**Consultation Response from KC,
Highways Development Management**

2023/92757 2, Thistle Hill Avenue, Lascelles Hall, Huddersfield, HD5 0AX

**Erection of front porch, single storey rear extension, erection of first floor extension to garage,
external render to dwelling, formation of vehicular access**

Date Responded: 06/02/2024.

Gabion detail for parking area

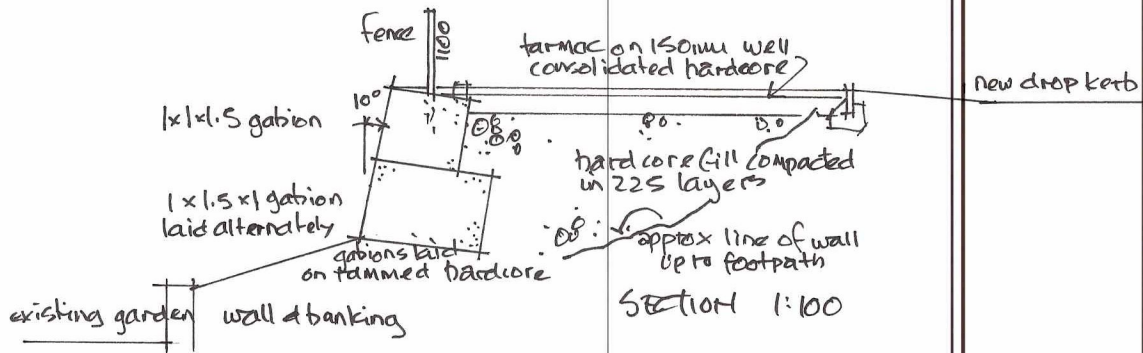
The proposals are acceptable from a Highways perspective subject to a revised layout showing that the required visibility splays to the proposed new parking area can be provided. This is to ensure that the minimum visibility can be met for vehicles leaving the new vehicle parking area.

The proposed new parking area is in addition to the existing driveway and garage and will provide an additional two parking spaces with a new access from Lower Hall Road.

For a 30mph speed limit sightlines of 2.4 x 43m should be provided for the new access unless the applicant can show evidence that the 85th percentile wet weather speed is below 60mph in which case the sightlines can be lowered accordingly.

Nothing shall be permitted to be planted or erected within a strip of land 2.4m deep measured from the carriageway edge of Lower Hall Road along the full frontage of the site which exceeds 1.0m in height above the level of the adjoining highway. This should be in place for the lifetime of the development.
